2024/0232

Address: 103 High Street, Penistone, Barnsley, S36 6BR

Description: Removal of existing flat roofed side extension, and erection of 3 storey side extension including integral garage

drg title
Proposed Elevations

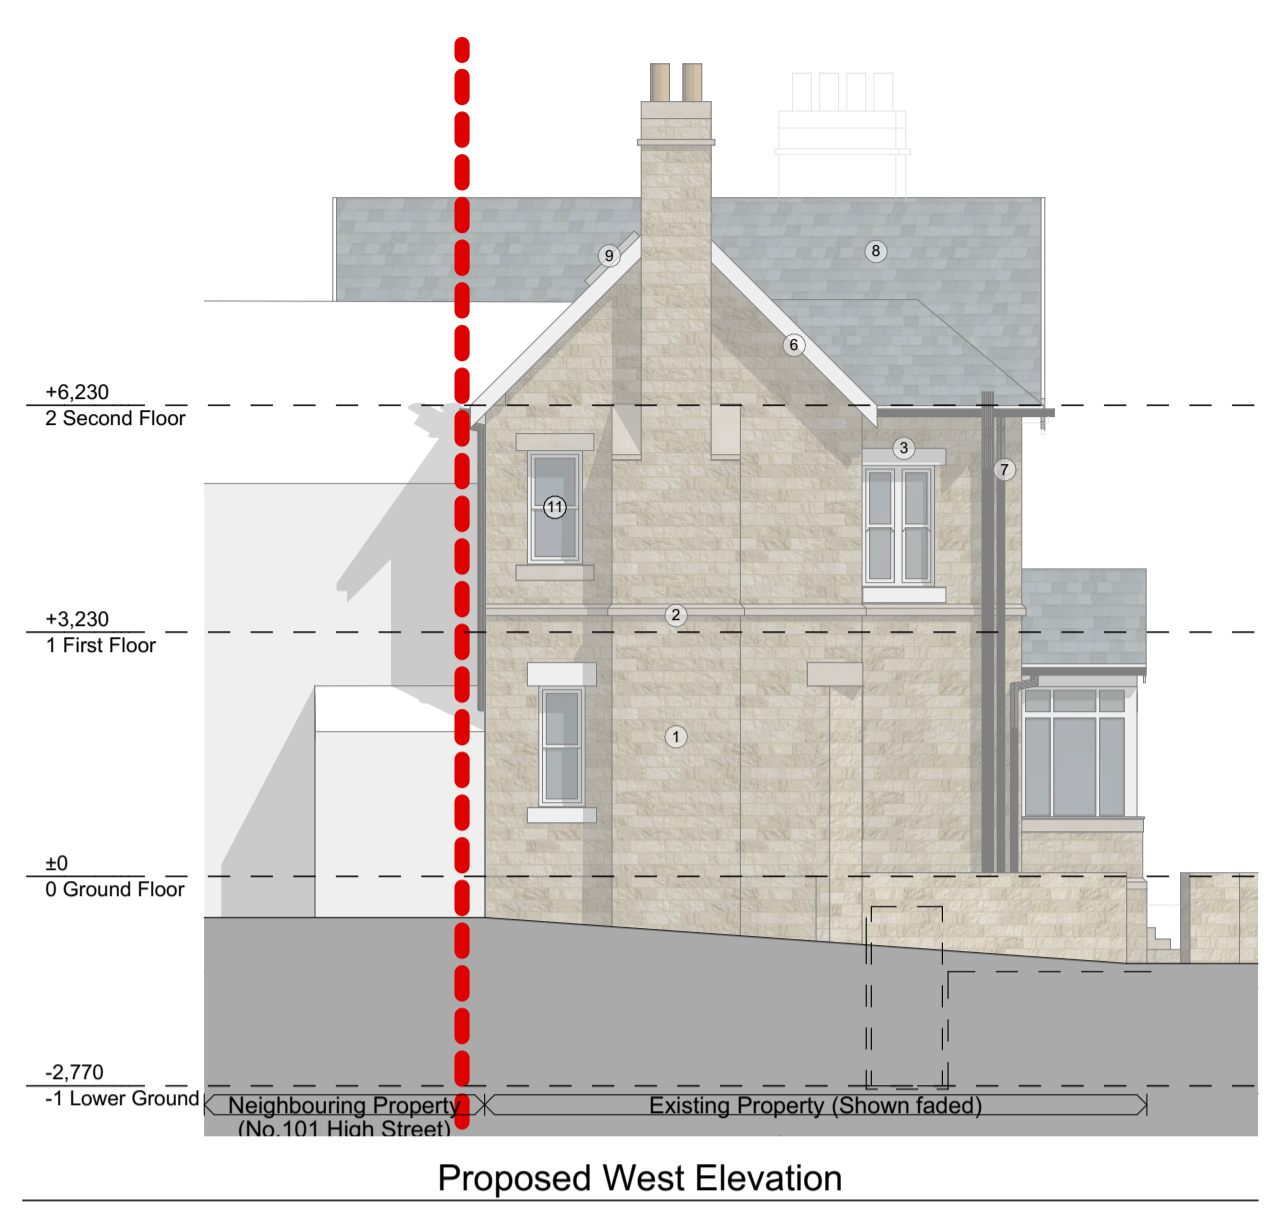
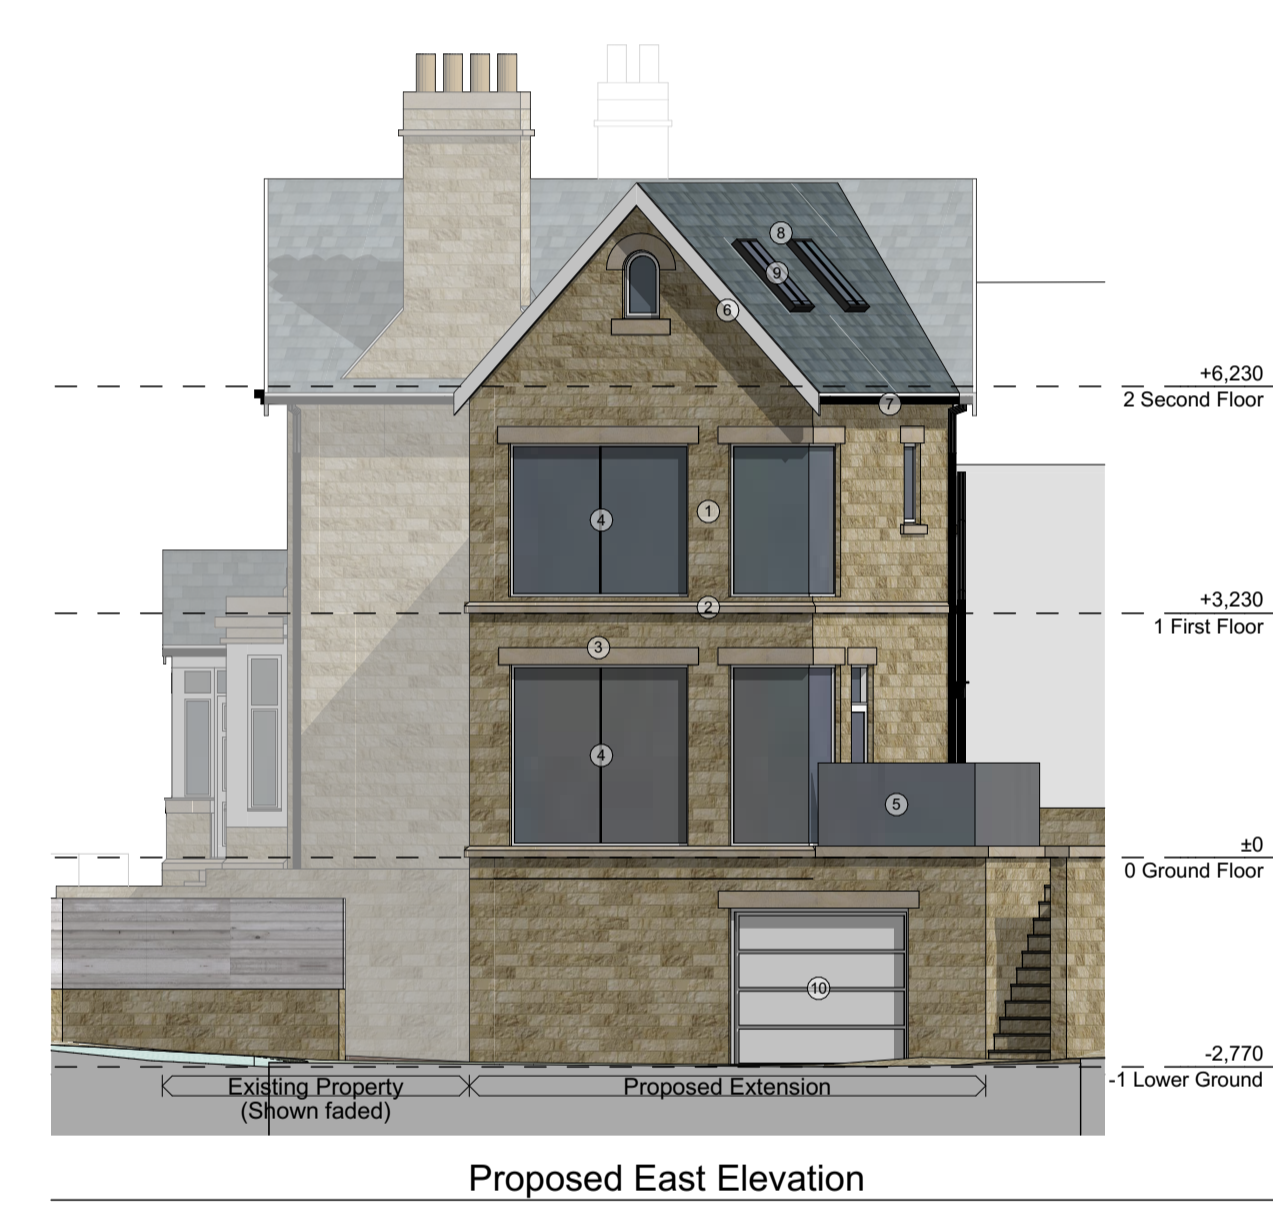
issues and is supported by the conservation officer. Conditions to ensure the use of matching materials was suggested, along with the use of conservation roof lights, which have now been included on amended plans.

"In terms of the overall principle of the extension I feel it suits the existing building and the location well. Whilst the extension results in quite a large elevation that fronts onto Green Road, I feel it provides balance and a degree of symmetry that completes the appearance of the building when viewed from the south. On each opposing corner of the junction there are similarly large buildings (the redeveloped sawmill site and Rotherwood), so the visual massing and scale is not unacceptable for the locality. This and the sympathetic details and materials means I support the proposal and raise no objections."

In contrast to the original proposals included as part of a pre-application enquiry at the application address, for a similar style extension, the current proposals present a revised and sympathetic proposal to the character of the existing dwelling. With conditions to ensure matching materials, the proposal would maintain the character of the dwelling whilst at the same time not having an adverse effect upon the broader street scene of Green Road, and barely any impact upon the street scene of the High Street. Although there is no set back or set down of the roof, the dwelling is of a unique design with various existing projecting elements and the proposals, especially in relation to the replacement of the existing extension, enhance the character of the dwelling and would not affect the varied street scene.
